## **National Highways A12 JN19-25 Expansion – DCO Application Examination**

### **Marks Tey Parish Council Issues with Junction 25 Proposals**

Map Book 6: Junction 25

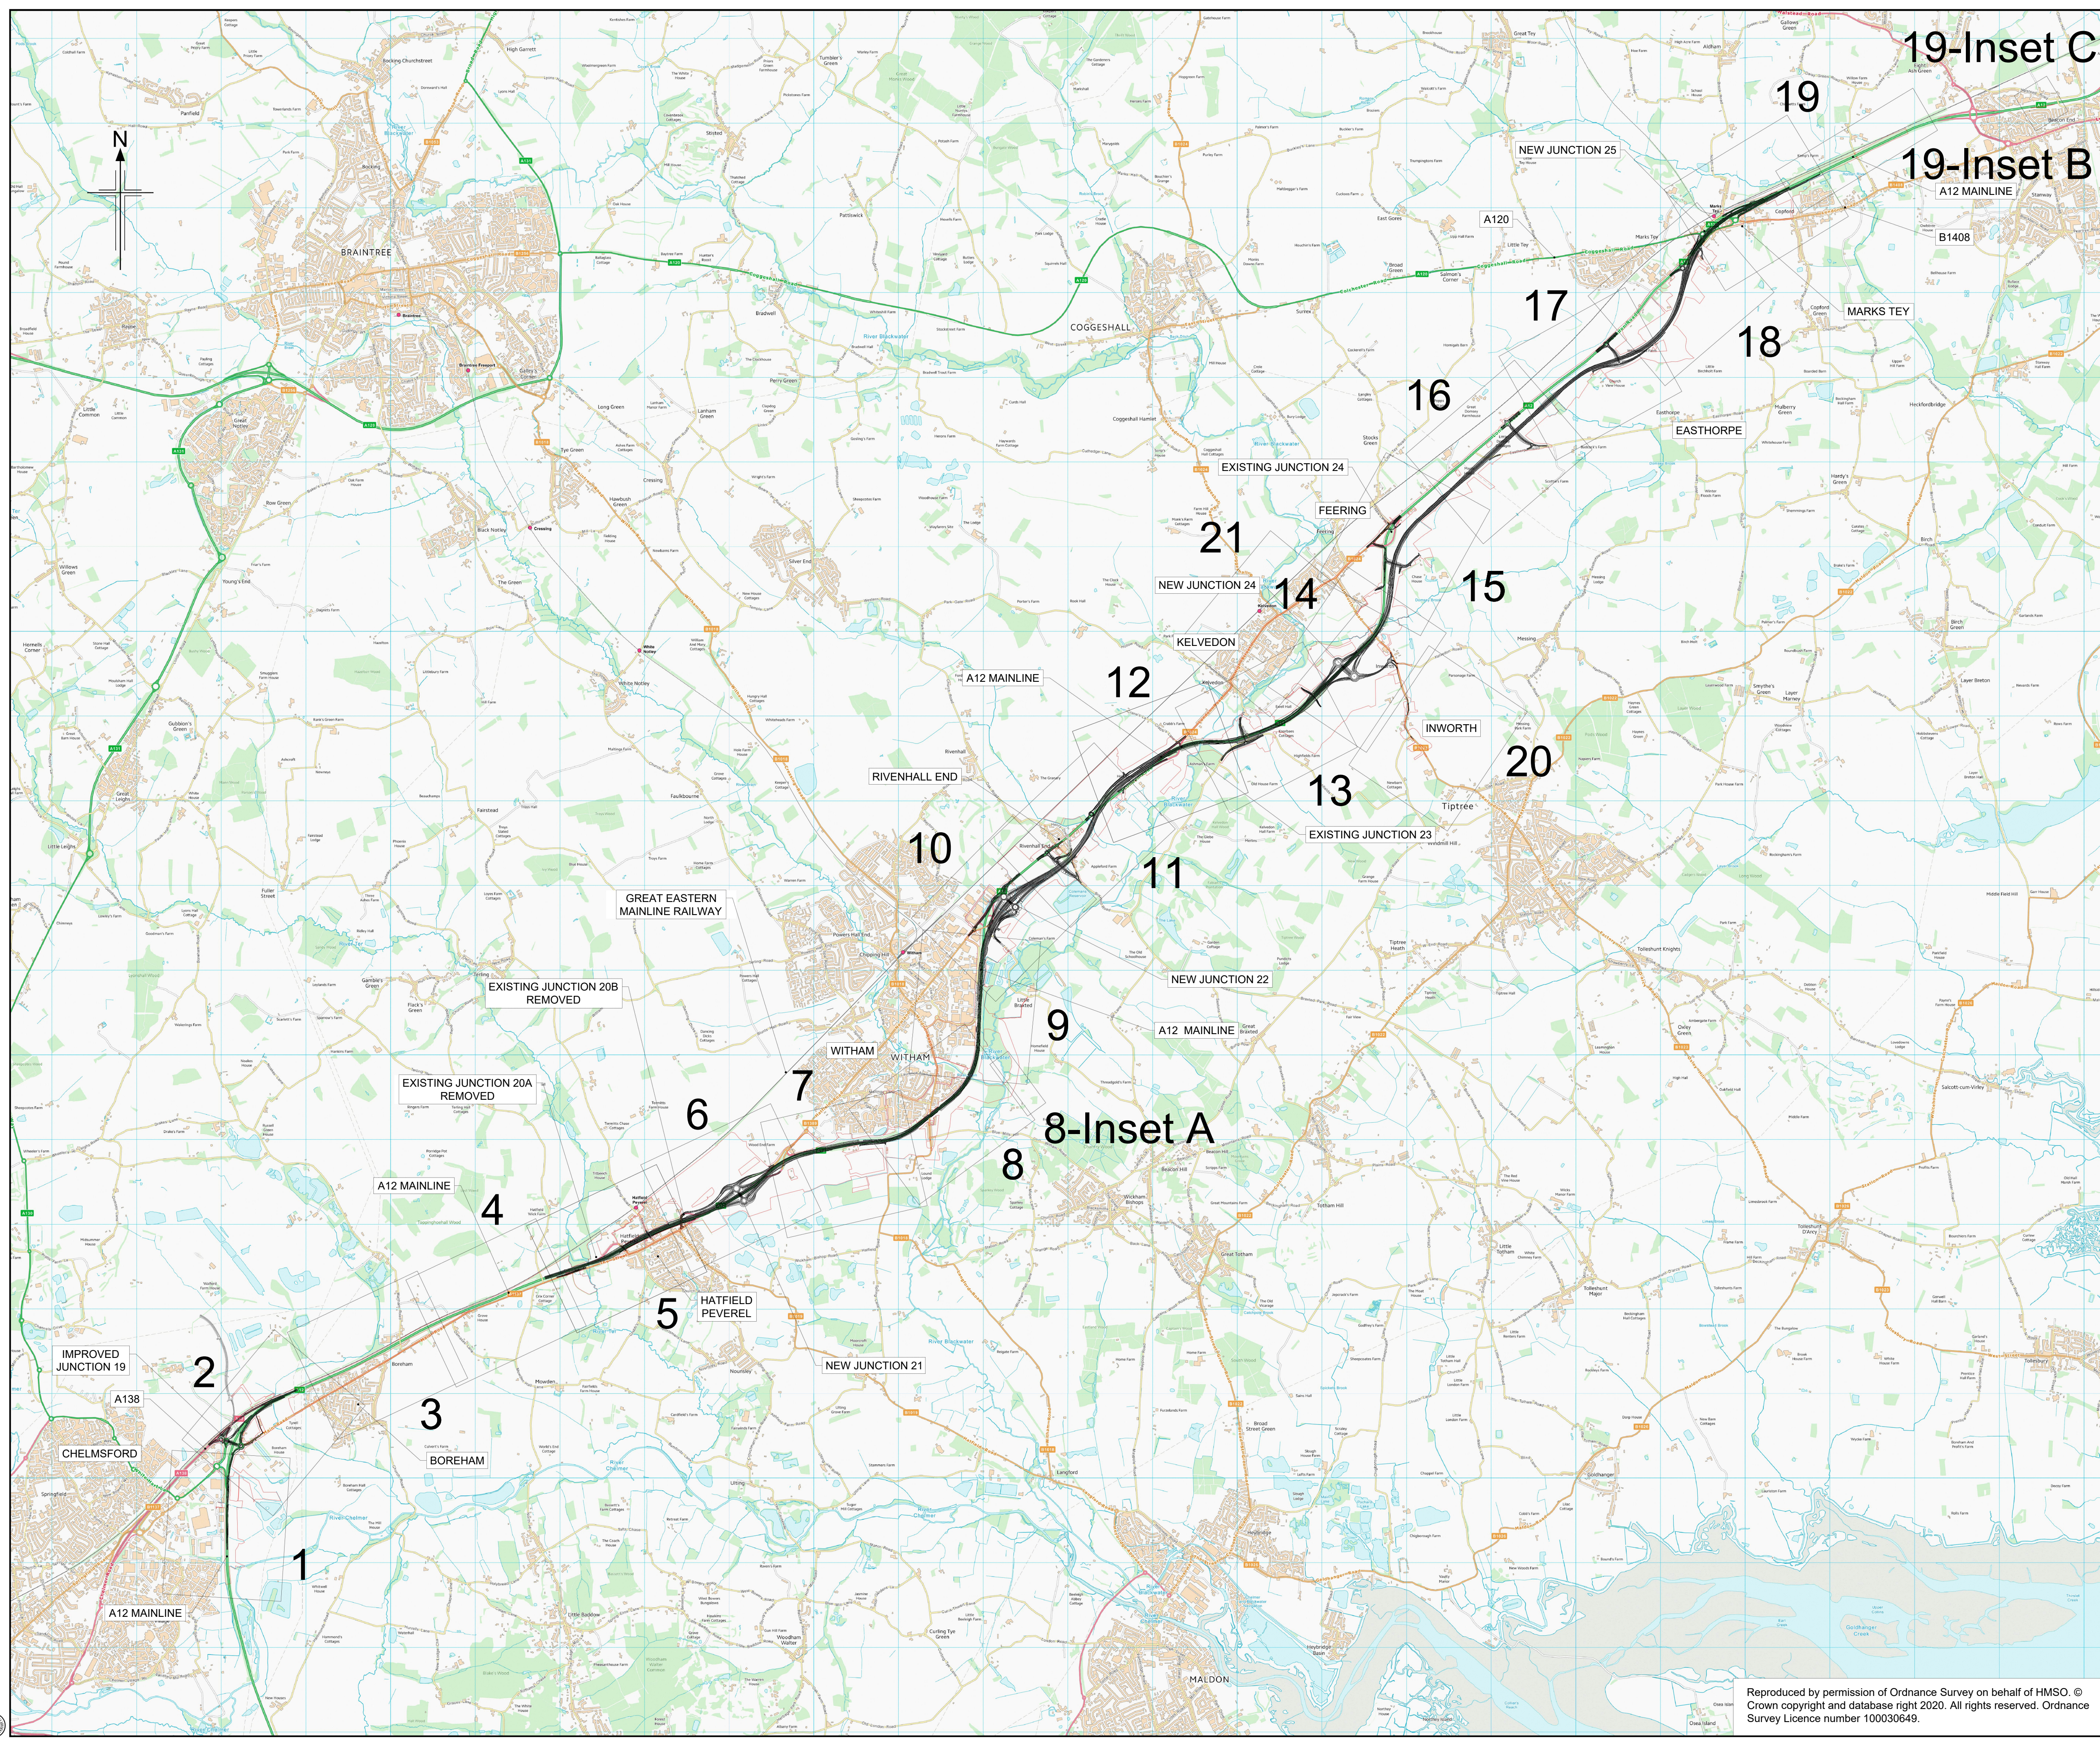
- The existing Old Rectory roundabout at the junction of Old London Road and the A120 single carriageway and dual carriageway and its 16 mature trees creates a break between the major Highway and the residential area. National Highways proposals to remove this roundabout and replace it with a series of multi lane traffic lit crossroads creating a sea of asphalt where the 16 trees were.

1. Concern that the removal of the Old Rectory roundabout and its 16 mature trees at the end of the A120 dual carriageway for a multi lane traffic lit crossroad is a significant degrading of our urban environment. The cross road solution is partially justified by National Highways on the volume of traffic flowing east on the substandard single carriageway A120 through the village when this traffic is currently restricted by slow moving traffic and queuing through Little Tey, Gt Tey Road junction, through Marks Tey village itself (Coggeshall Road), and the blind railway bridge. The existing roundabout and mature trees should be retained even if an additional lane needs to be added and the roundabout traffic lit. Further capacity improvement can be dependent on decisions on the future of the A120
